From: Simon Davis
Sent: 03 November 2020 17:33
To: 'Natalie McKellar' [REDACTED]
Cc: 'Kerry Simmons' [REDACTED]
Subject: Springfield, Hook Lane, AL/64/20/PL - Drainage

Drainage Strategy				Draining The
Engineering Details				
Drawn	Checked	Scales	Paper Size	Date
JN		1:250	A1	08.19
Job No.				Revision
KNC/1932	602-01			C

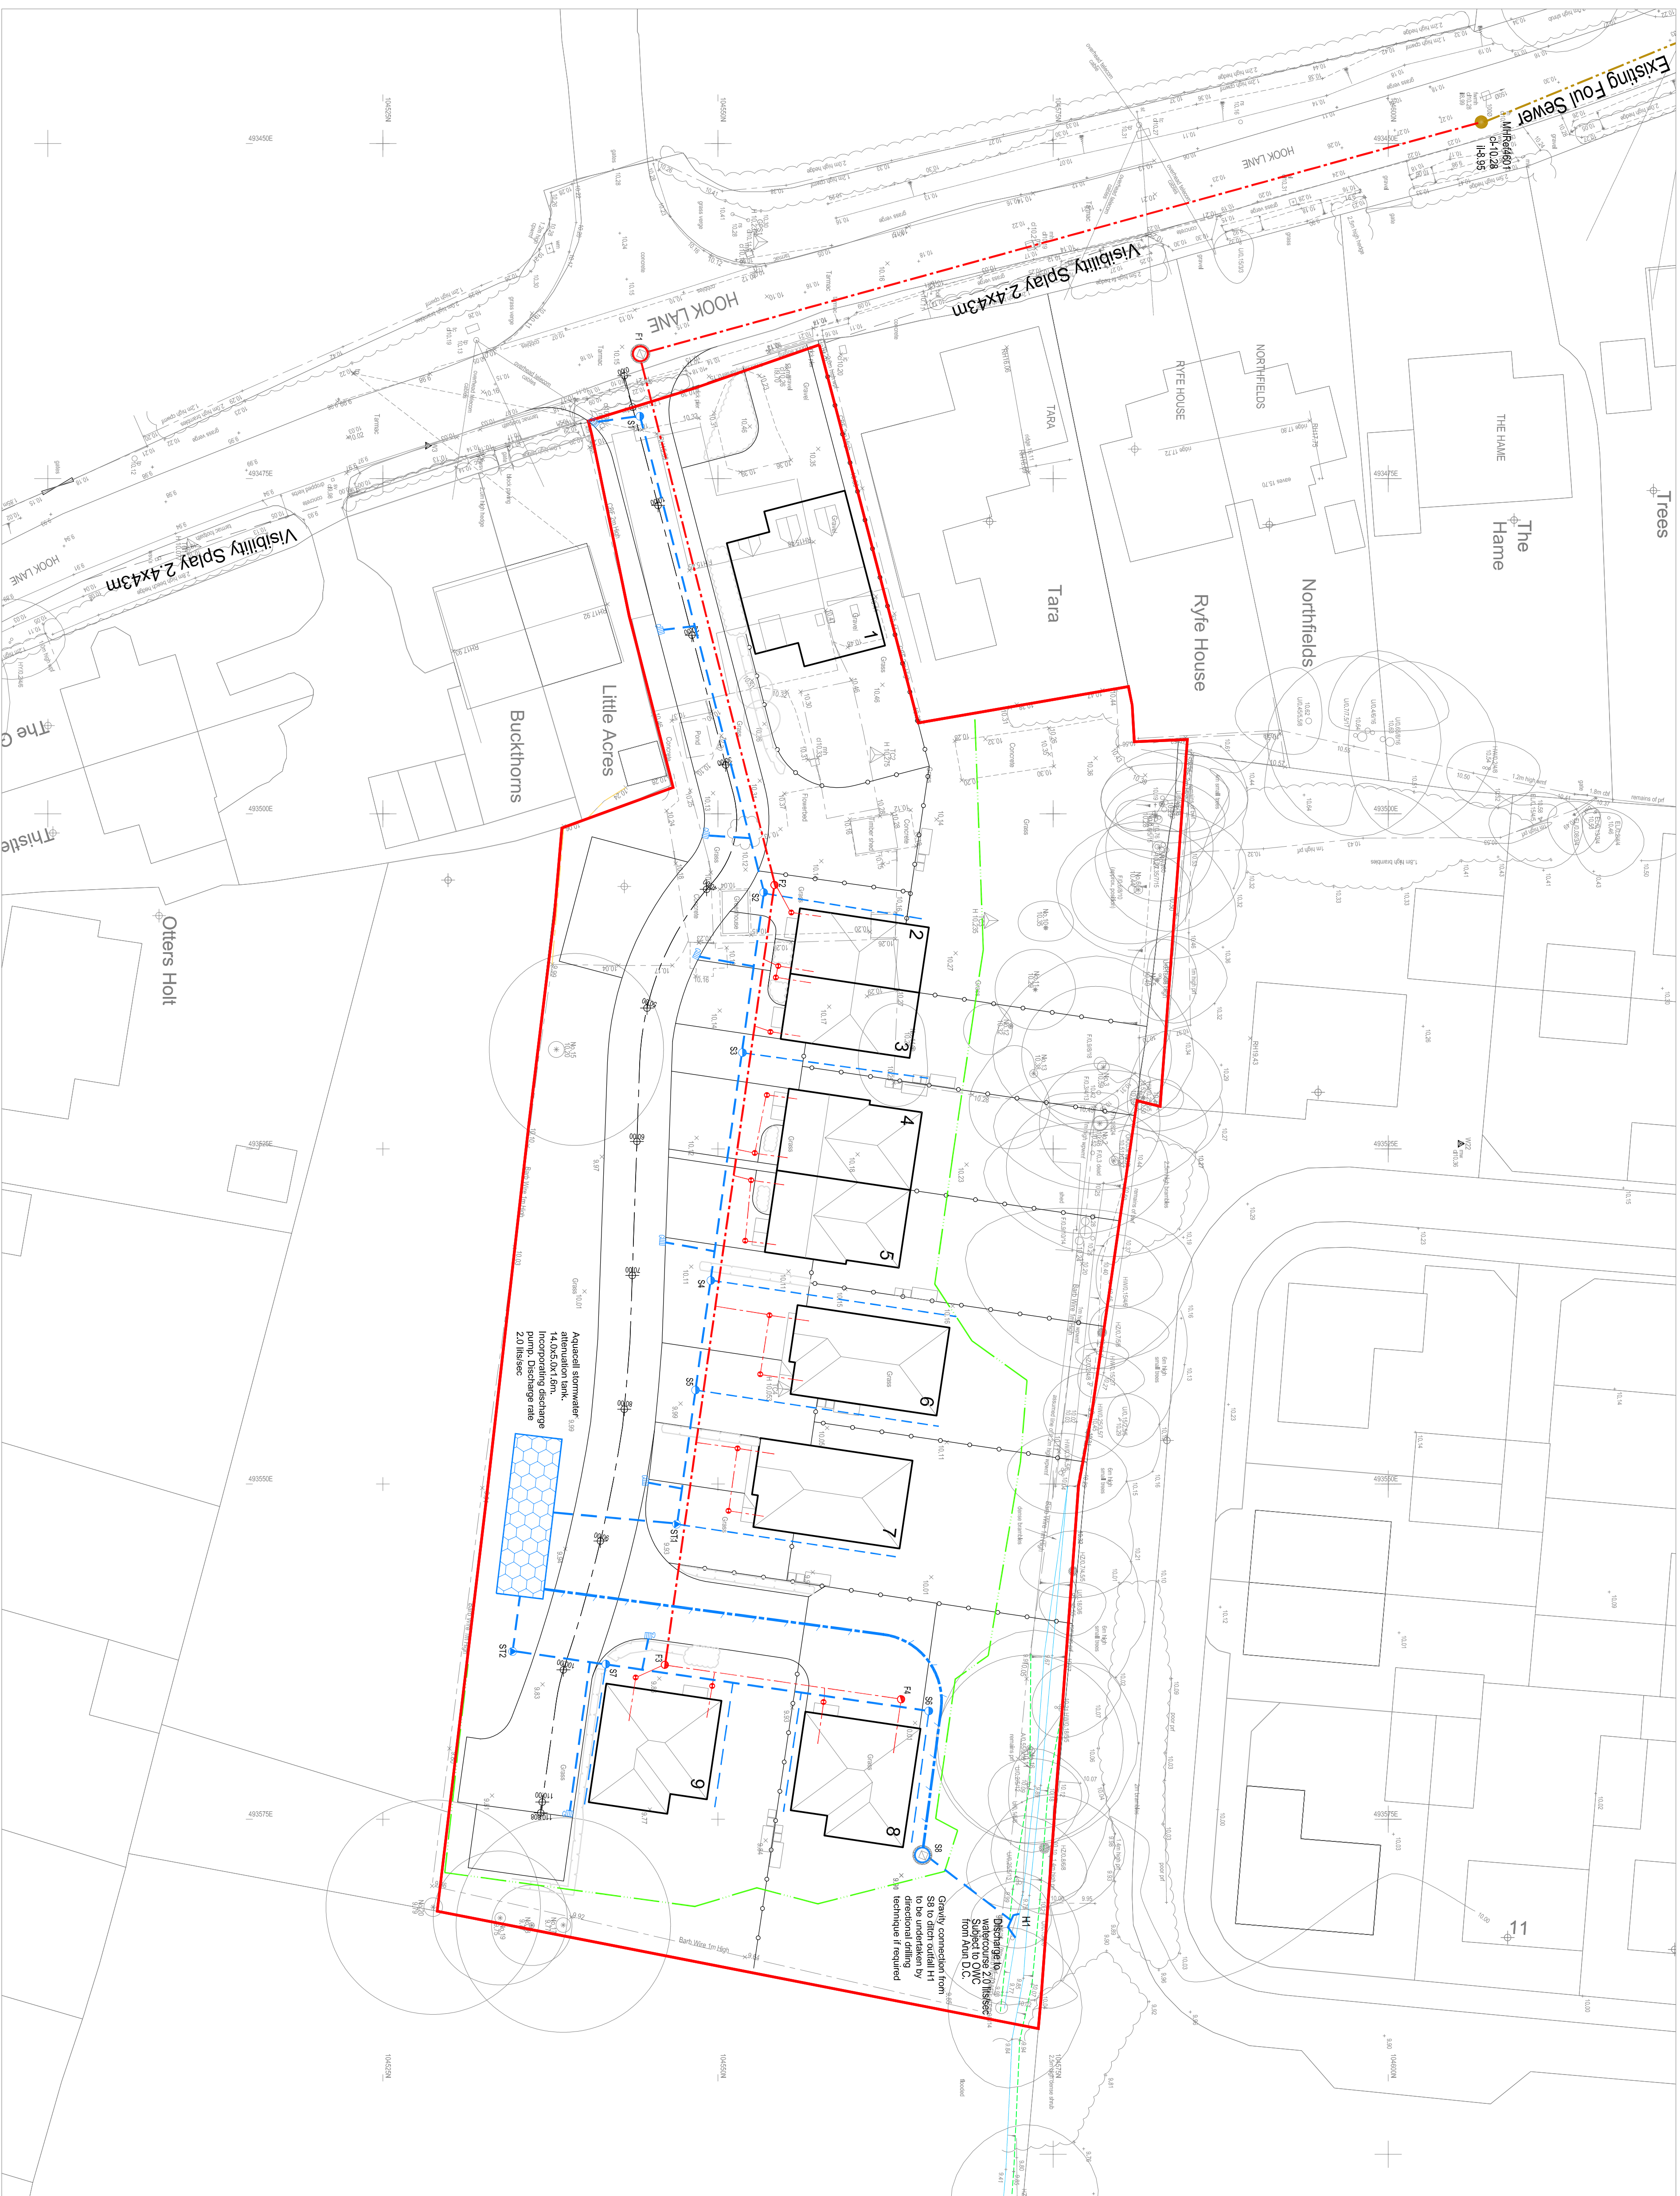
I write separately to my two emails today. I wonder did you note the drainage comments on our website as received 13/10/20? I initially missed these but if you review them, you'll see that they request that boundary fences are kept at least 3 metres away from the banks of the northern boundary ditch in order to allow for future. They also request that the true extent of the ditch is established to take account of recent works undertaken by BDW. They state this matter must be resolved before the layout is agreed.

No development above damp proof course (DPC) level shall take place until details of all new screen walls and fences have been submitted to and approved by the Local Planning Authority and none of the approved dwellings shall be occupied until such screen walls/fences associated with them have been erected. The submission of such details shall include an up-to-date survey of the ditch running along the northern boundary to take account of recent works to it as undertaken by Barratt David Wilson in respect of the adjacent site; and also the measures required to ensure 3m easements from the opposing banks of this ditch including the use of demountable fencing where appropriate.
